From: skelly@richardbuxton.co.uk
To: hornseaprojectthree@pins.gsi.gov.uk
Cc: "Mulbarton Parish"; [REDACTED]
Subject: EN010080 - Hornsea Project Three, Deadline 8 Representations on behalf of Mulbarton Parish Council
Date: 20 March 2019 11:12:46
Attachments: [Ltr_Mulbarton Parish Council_EN010080.pdf](#)

Planning Inspectorate Reference: **EN010080**

Application by Orstead Hornsea Project three (UK) Ltd for an order granting Development Consent for the Proposed Hornsea Project Three Offshore Wind Farm (the Application)
Application Reference: EN010080

Deadline 8: Representations on behalf of Mulbarton Parish Council

Figure 3.8: Shortlisted Substation Options.

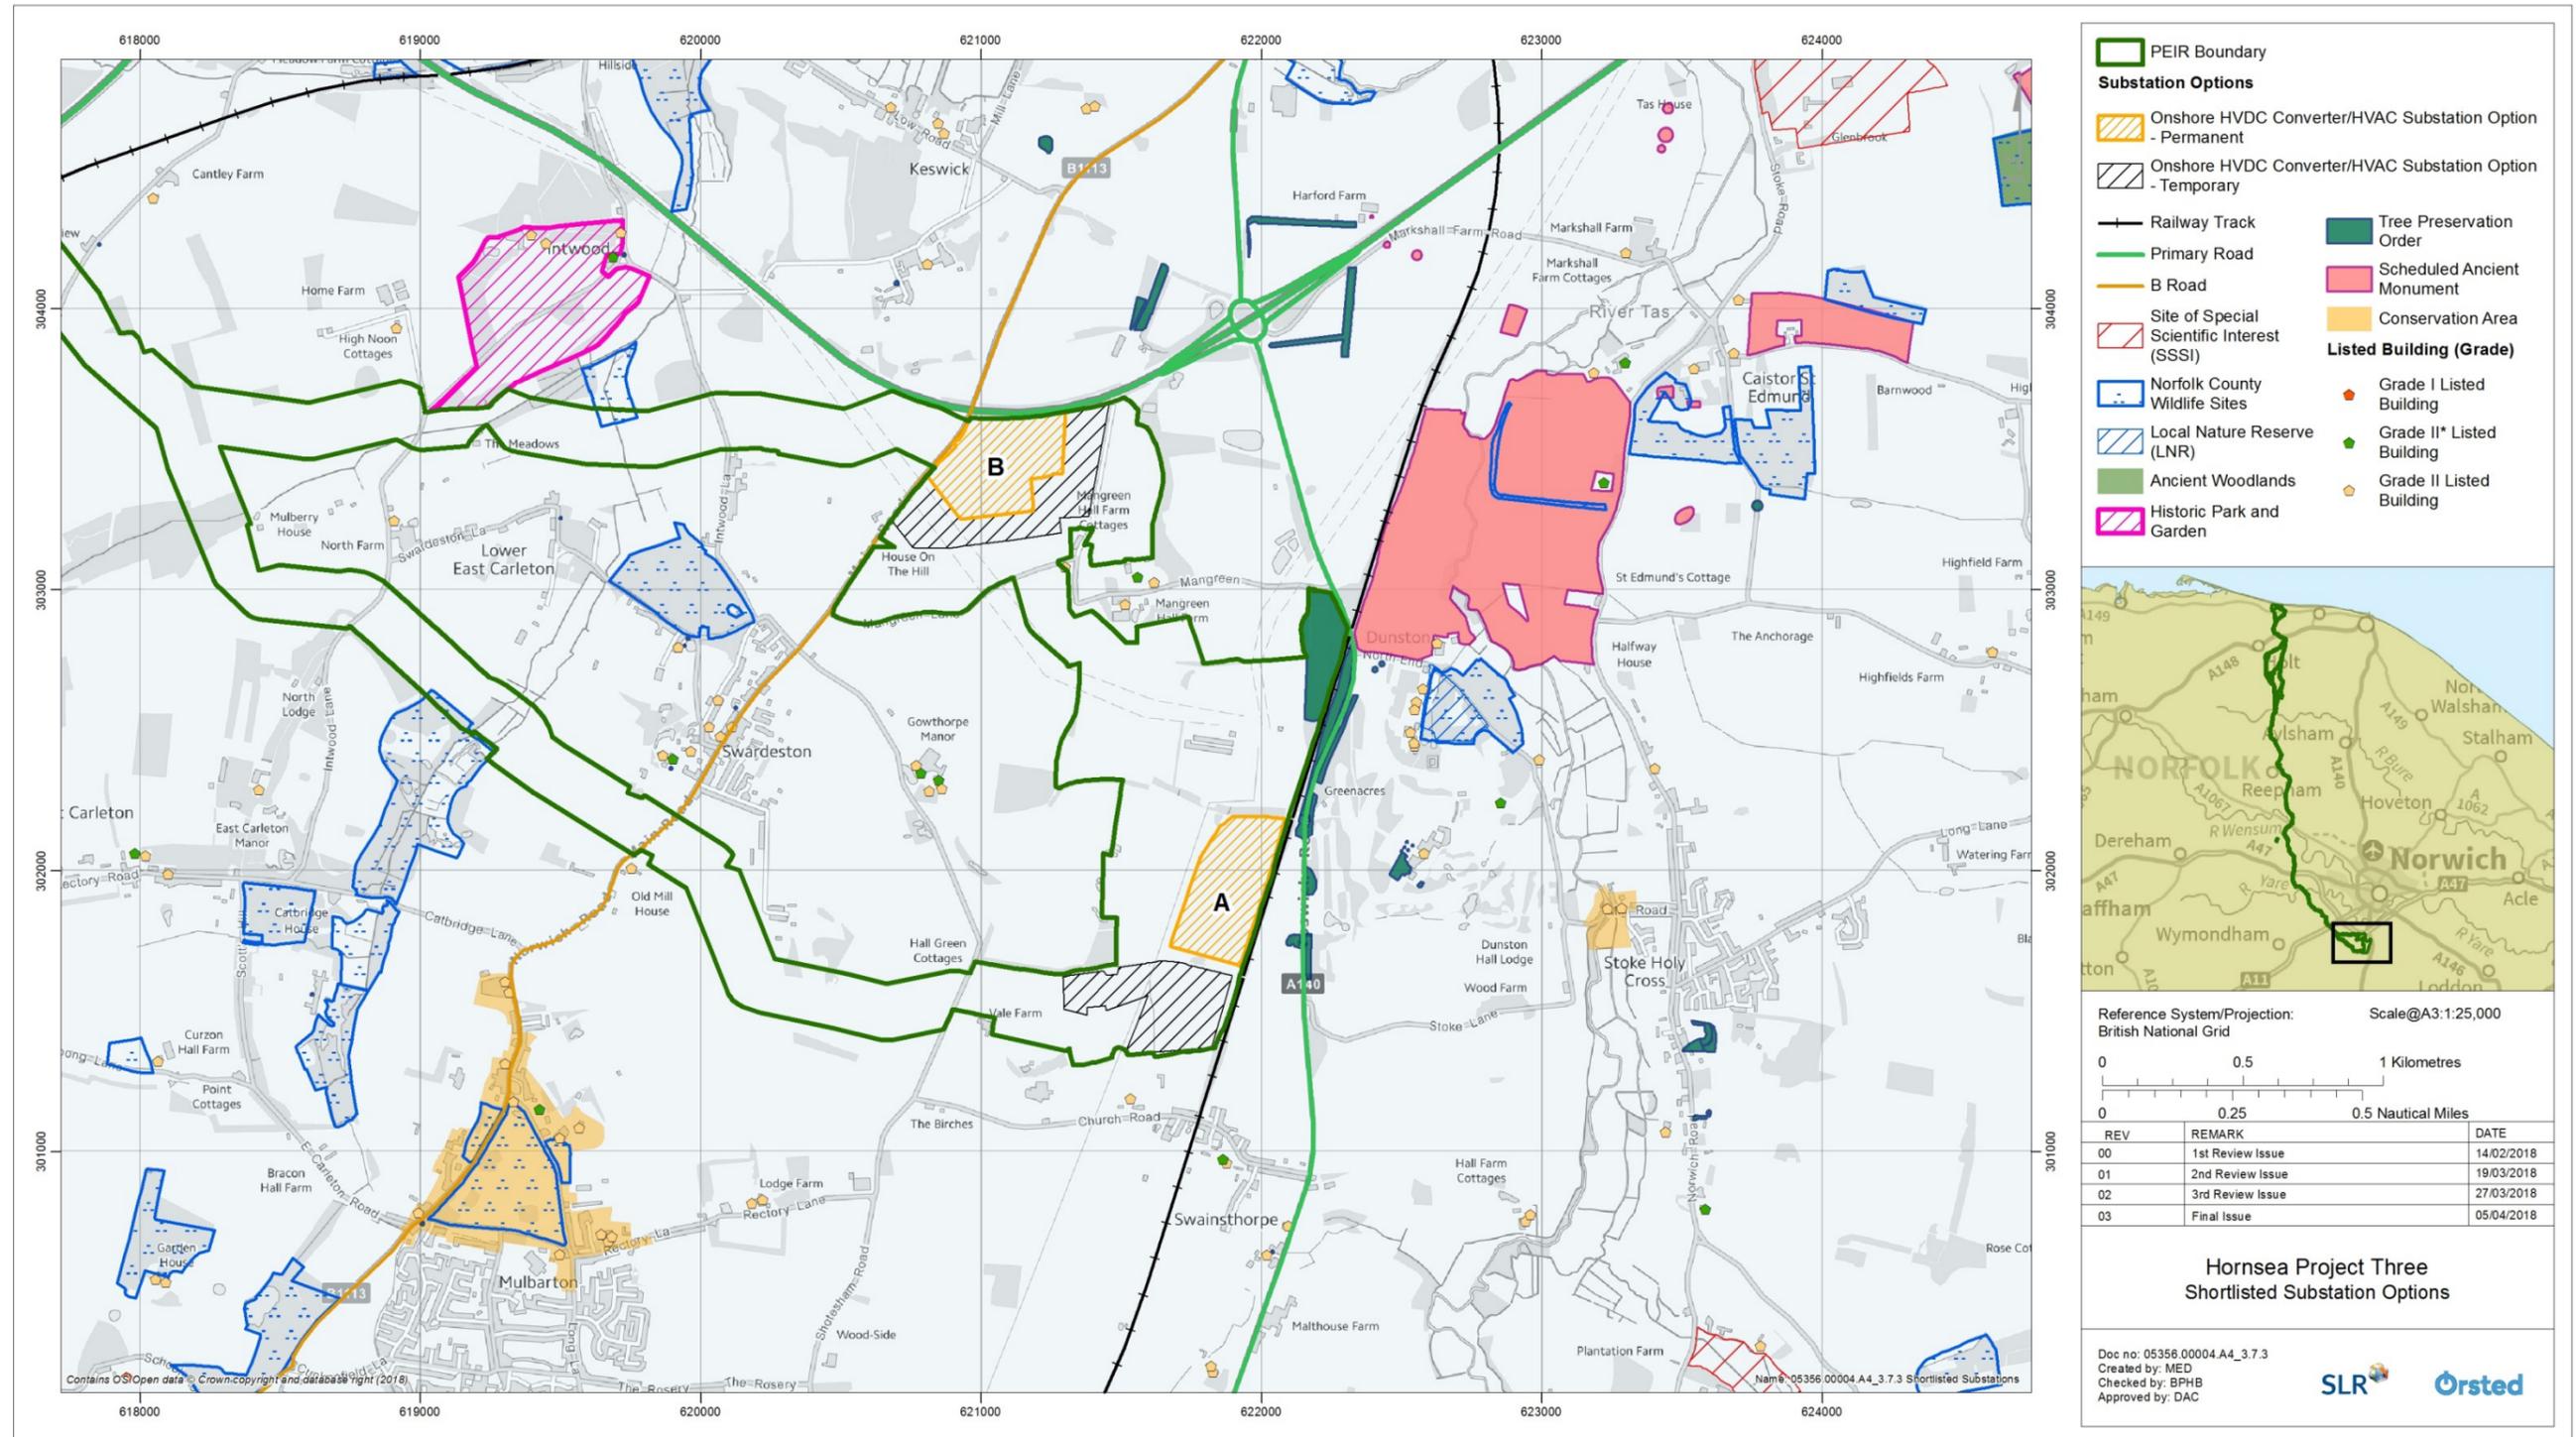
25. The Applicant's assessment of the relative merits of Options A and B is set out at table 4.4 of The Alternative Sites Assessment. The Applicant's reasons for preferring Site B are set out in table 4.4. However, it is unclear from this table, what specific considerations the Applicant took into account in reaching that conclusion.

26. Somewhat more detailed comments are contained at paragraphs 4.10.7.16 and 4.11.5.2 of The Alternative Sites Assessment. Paragraph 4.10.7.16 of The Alternative Sites Assessment records that both Options A and B are:

"... positioned positively in relation to the onshore cable corridor search area ... however, Option A's proximity to the railway line directly to the east and the Norwich Main substation to the north made it physically more constrained than Option B. Furthermore, Option B was

significantly less constrained in terms of both access and existing services and utilities, as well as possessing a greater availability of land for potential mitigation to be implemented”.

28. It appears therefore that the main concerns relate to accessibility and the availability of land for mitigation. The precise nature of that mitigation is wholly unclear from this document.

Figure 3.9: Substation A.

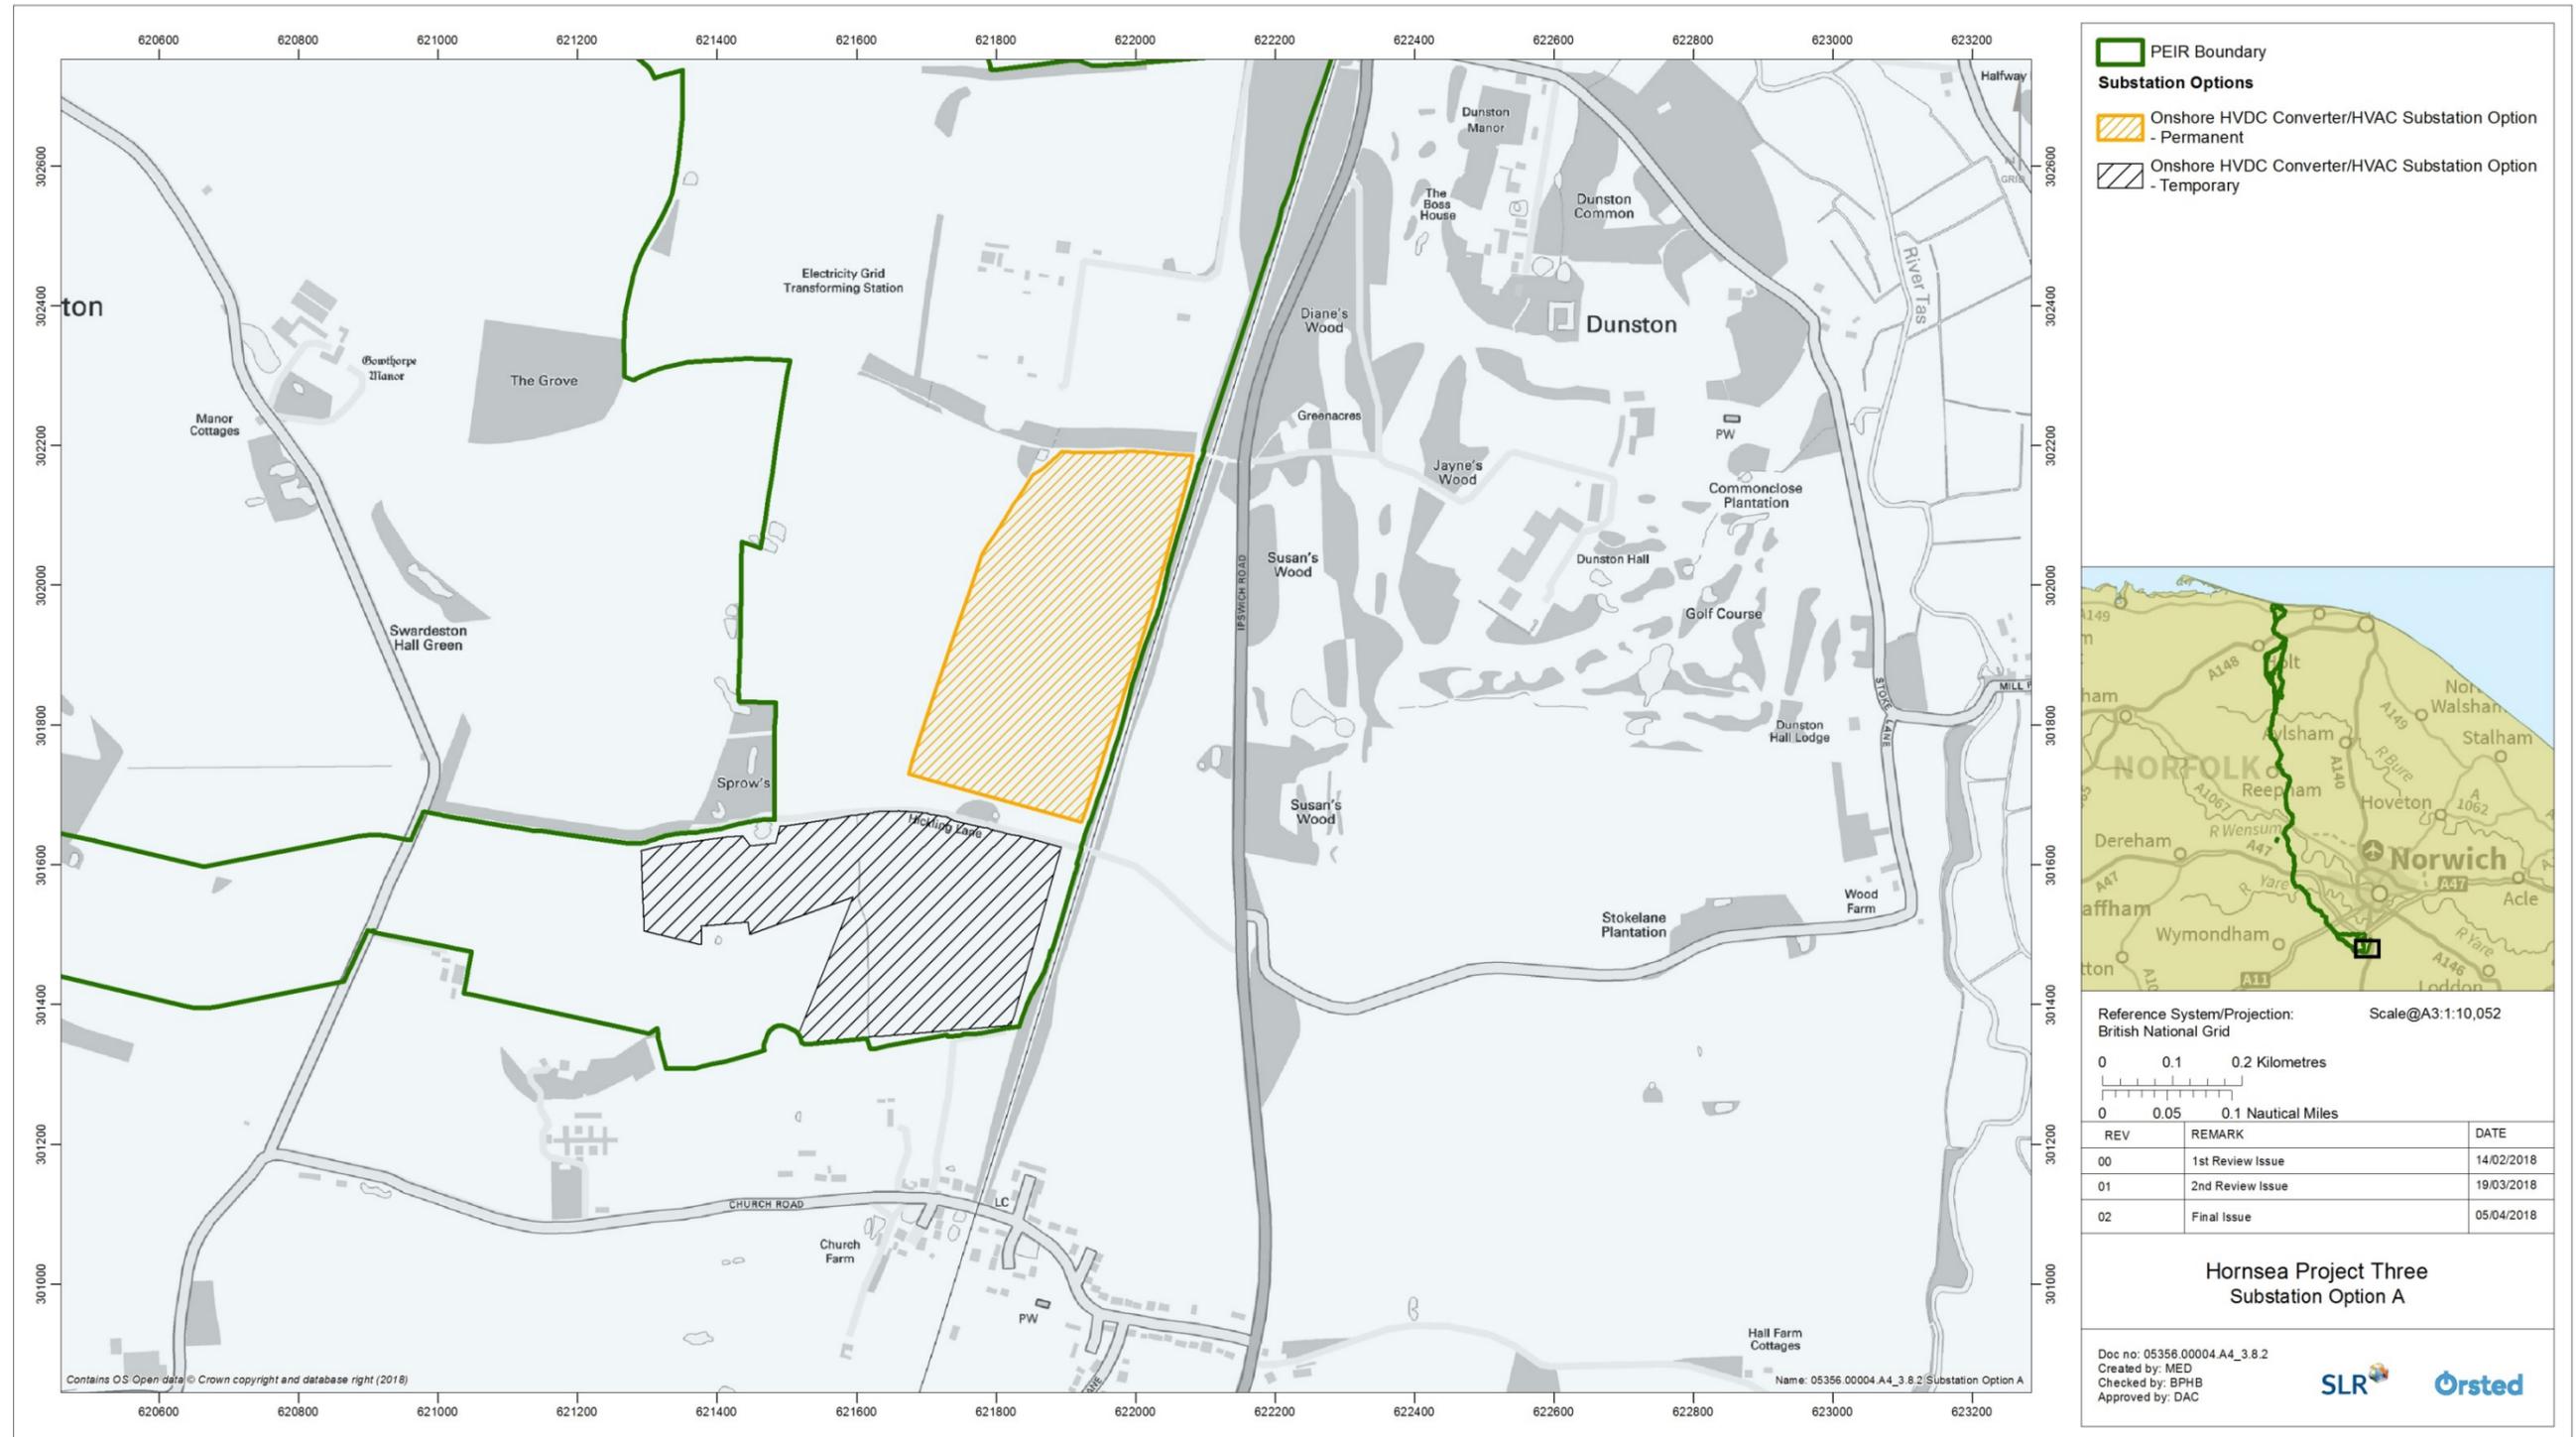
13. Option A is a roughly rectangular field, situated south of the existing electricity substation. The Option A site appears to have an ordnance level of 20-25m AOD, which is lower than the nearby substation (Landscape Assessment, Figure 4.8).

14. The site is bounded to the east by a railway line, beyond which is the A14 (and beyond that part of a golf course, and then the Grade II Dunstall Hall). Hickling Lane forms the southern boundary of the proposed operational site. The land to the west of the site boundary comprises further fields and woodland, beyond which is a public bridleway which continues the alignment of Gowthorpe Lane (Gowthorpe lane turns to the north west where it meets Hickling Lane) and forms an identifiable western boundary feature. The whole of this area (including the land to the west of the identified site) is included in the application’s PEIR boundary. Gowthorpe Manor (Grade II*) and related buildings lie further to the west, beyond a substantial bank of trees.

15. It is not immediately clear from the Applicant’s materials why the operational site boundary is so constrained to the west. There is no evidence that this site is covered by any landscape designations and in any event, the site is substantially screened by existing trees and woodland.

16. Access to the site is possible from Hickling Lane, albeit, it is also conceivable that access could be secured by extending the service lane to the existing substation through to the Option A Site. That service road gives access to the A140, which in turn is accessed from the A47 Norwich ring road. It is not clear from the Application materials we have reviewed in the limited time available, whether the potential for access using the existing substation service lane has been explored.

17. In local policy terms, the Option A site falls within the Norwich Policy Area as defined in Appendix 4 to the Joint Core Strategy for Broadland, Norwich and South Norfolk (amended January 2014); South Norfolk Joint Core Strategy 2014 (the JCS). The Norwich Policy Area is a larger area within which the JCS encourages major growth and development on sustainable sites (see for example, statement at Policy 9 of the JCS: “The Norwich Policy Area (NPA) is the focus for major growth and development”).
